WEST SUSSEX COUNTY COUNCIL CONSULTATION

TO:	Arun District Council FAO: Maria Tomalova
FROM:	WSCC - Highways Authority
DATE:	20 October 2020
LOCATION:	Babsham Business Park Babsham Lane Bognor Regis PO21 5EL
SUBJECT:	BE/92/20/DOC Approval of details reserved by condition imposed under ref BE/89/19/PL relating to Condition Nos 2 - car parking spaces, 3 - acoustic assessment, 4 - mitigation & remedial strategy for reptiles, 11 - access road, 12 - bat boxes and 13 - dust control.
DATE OF SITE VISIT:	n/a
RECOMMENDATION:	Advice
S106 CONTRIBUTION TOTAL:	n/a

DRAWING TITLE
SITE IDENTIFICATION PLANS
SITE LAYOUT PLAN
STORAGE CONTAINER DETAILS

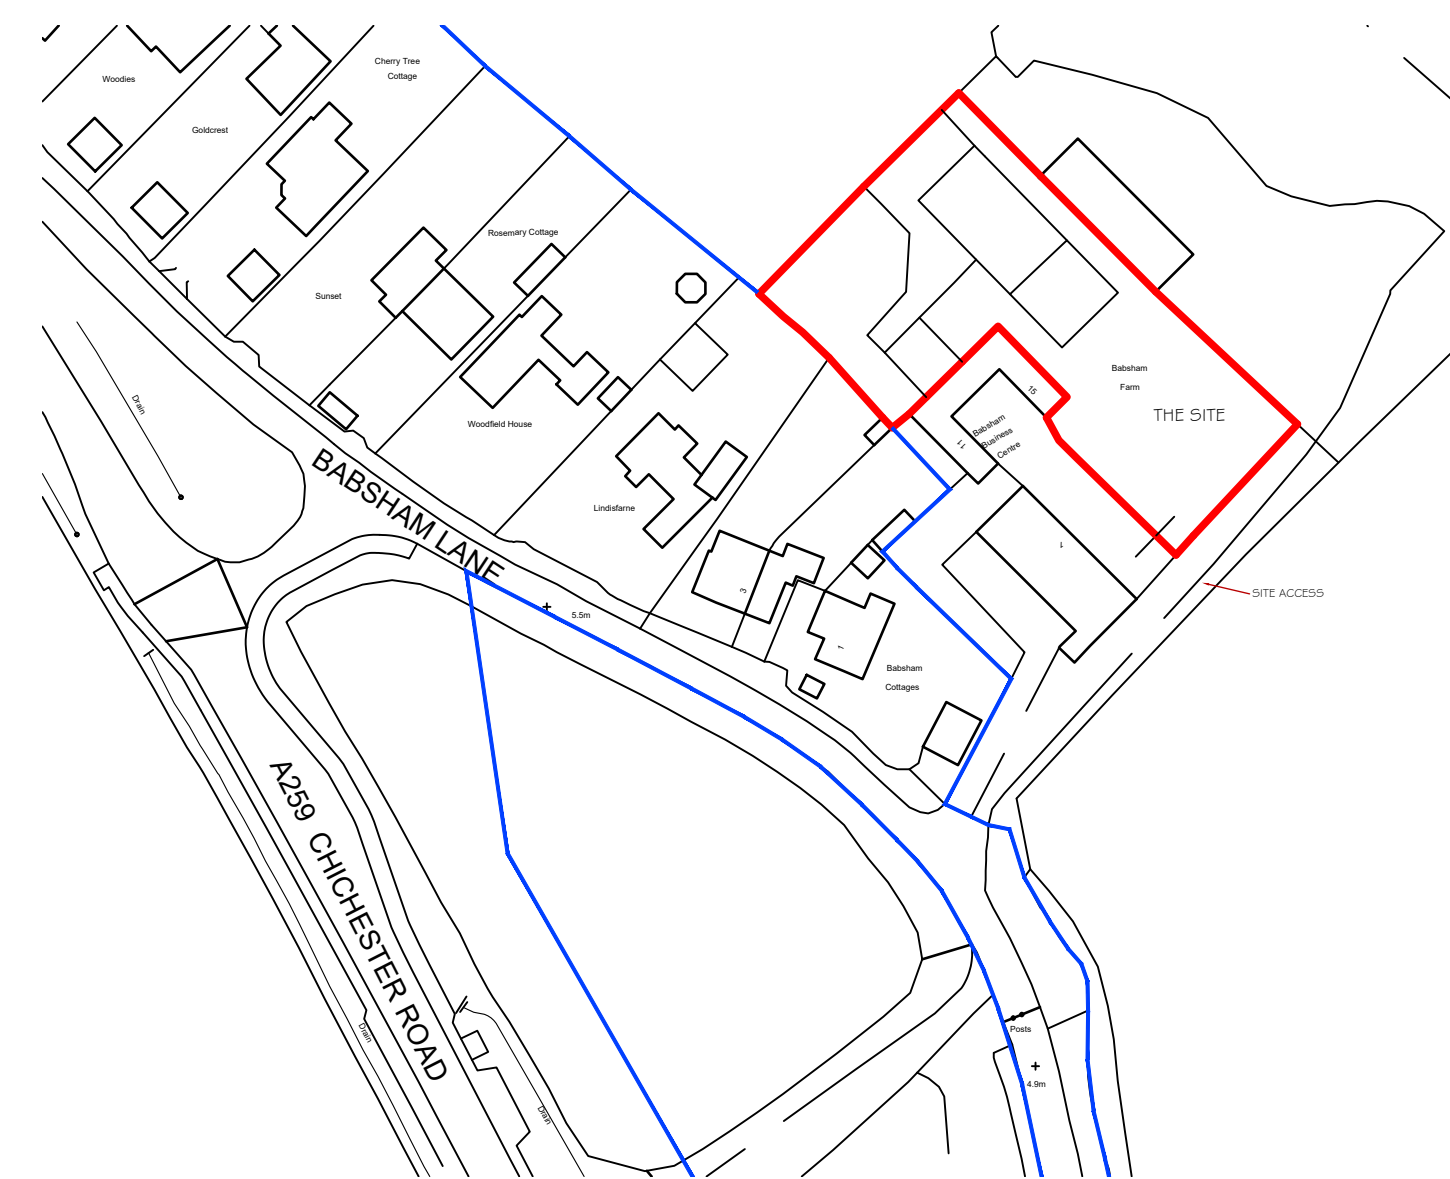
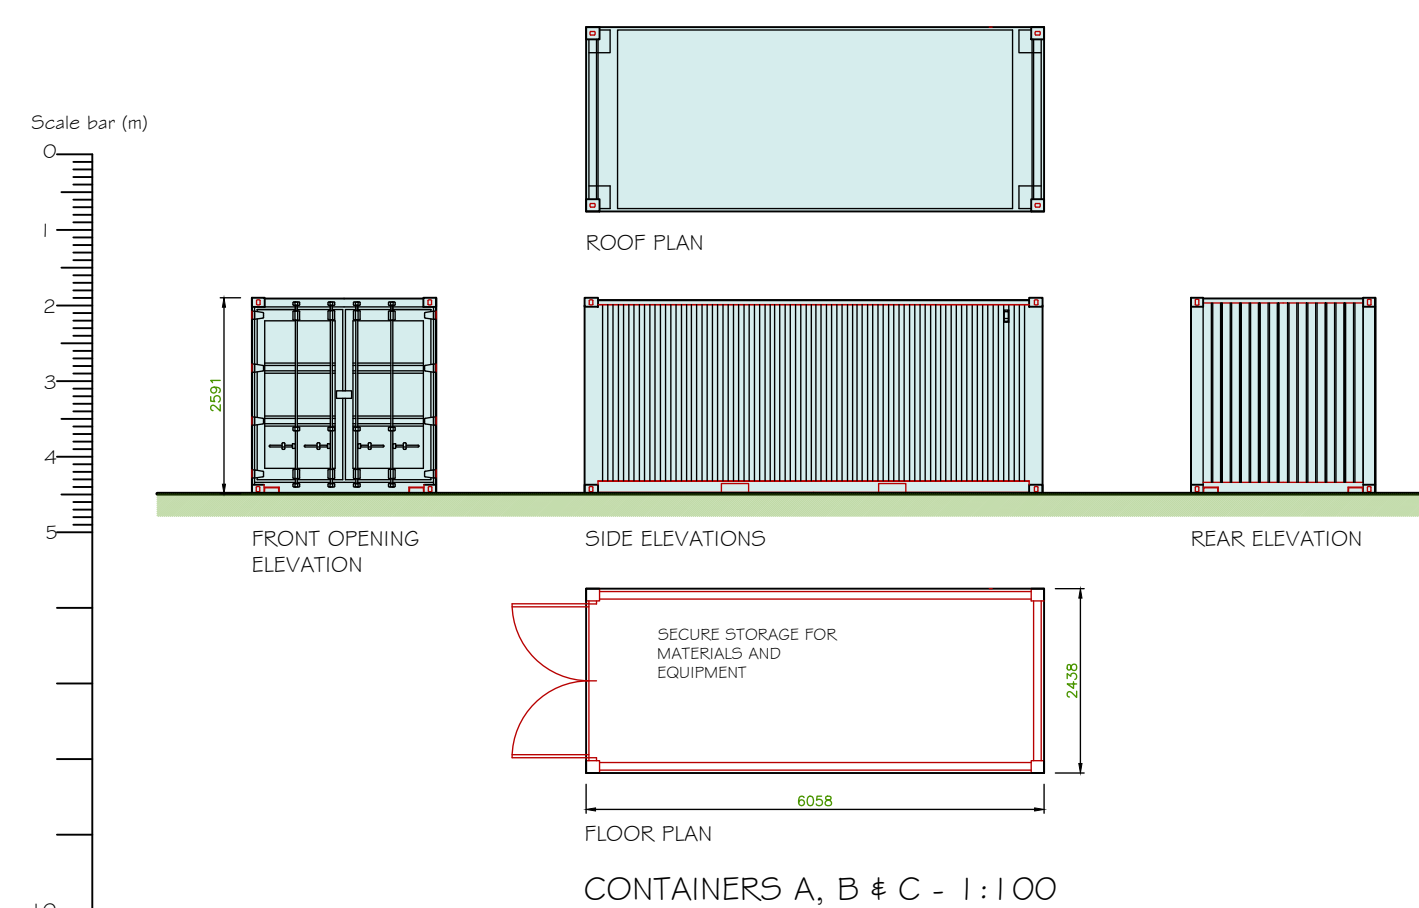
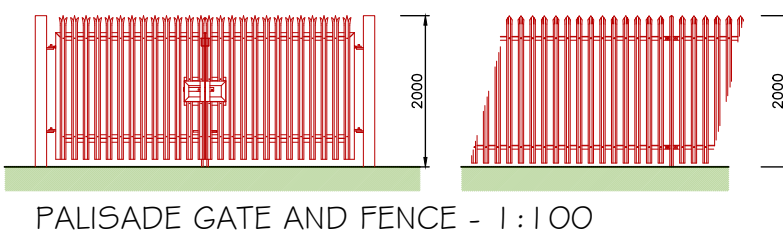
The applicant has demonstrated 8 vehicle parking spaces on site, each space meets minimum specifications as set out in Manual for Streets. There appears to be space for vehicles to turn on site and exit in a forward gear.

In conclusion, the LHA is satisfied that conditions 2 and 11 can be discharged. As stated above, the applicant may wish to surface the unmade section of the public highway within the access, to WSCC standards.

DRAWING TITLE
PROPOSED RESURFACING OF SITE ACCESS

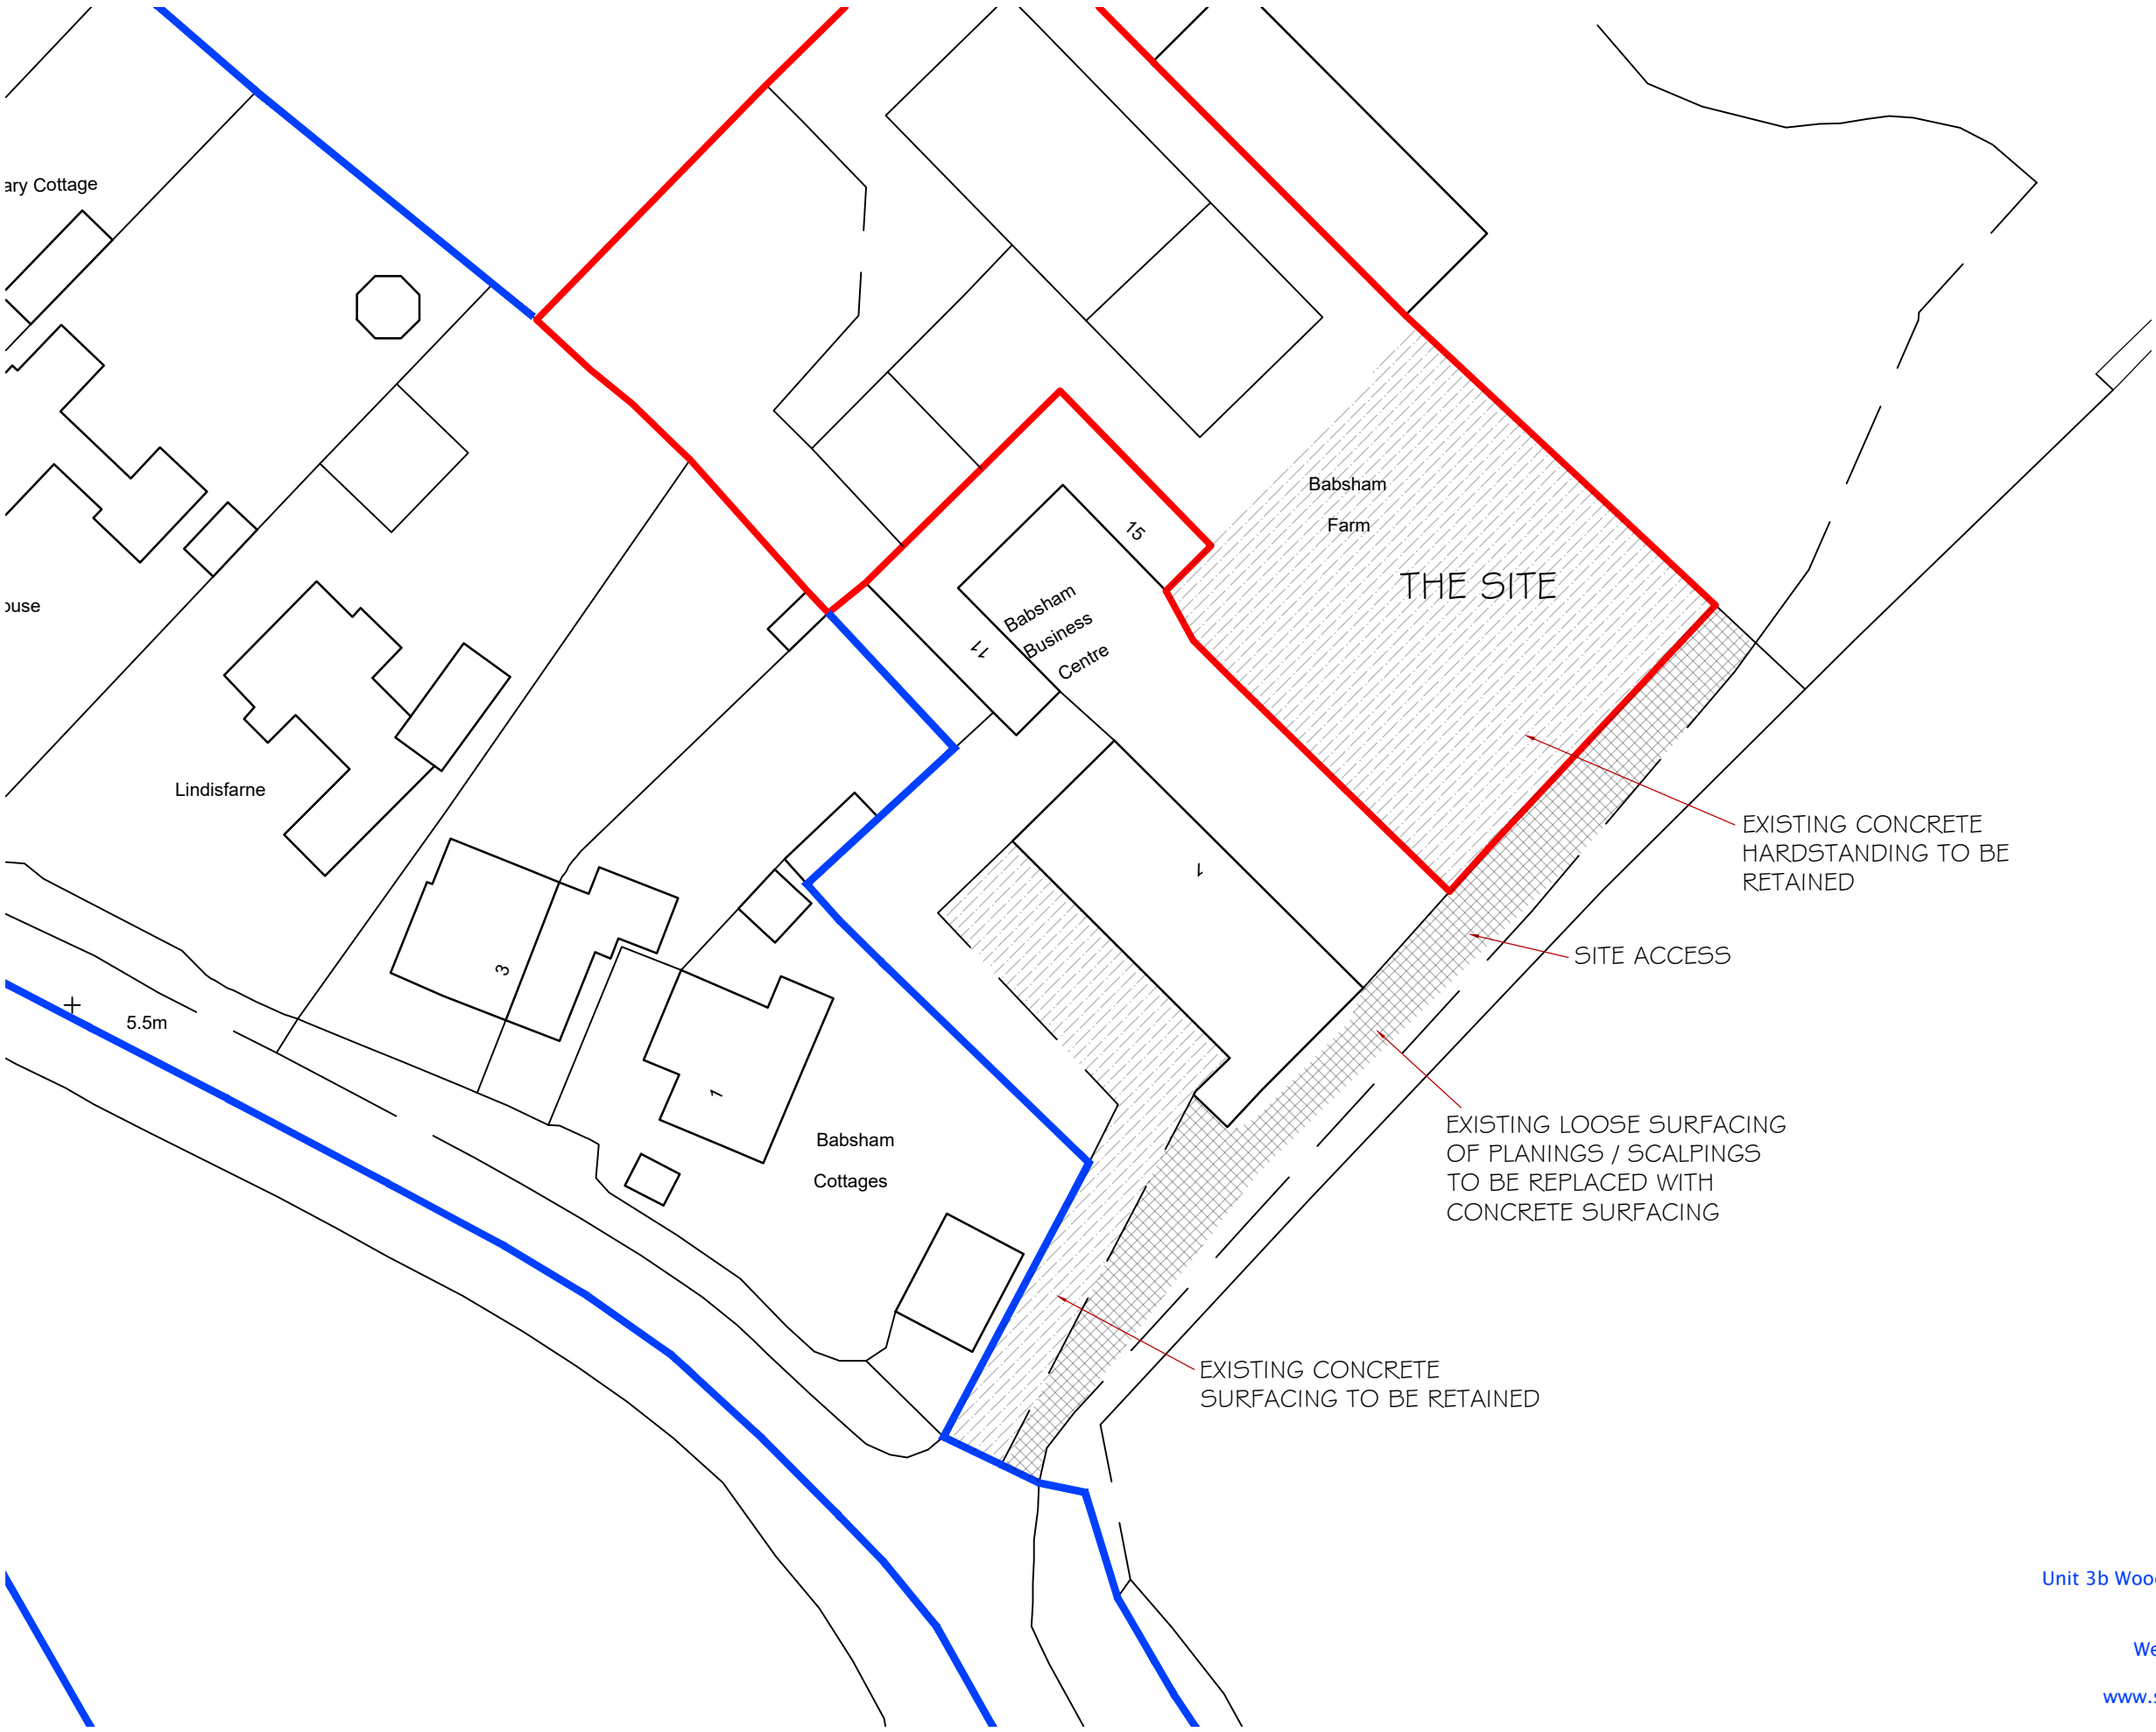
As this condition covers the internal access road up until the adopted highway boundary, the LHA's comments are for advice only. The internal access way width will remain the same, but will be constructed from concrete, this will prevent loose material from over-spilling onto the public highway and reduce dust. Mapping indicates that part of the access into the site, within the public highway will remain 'unmade'. The applicant may wish to consider extending the concrete surfacing up until the made surface of the public highway, this would need to be constructed under licence from the Area Office.
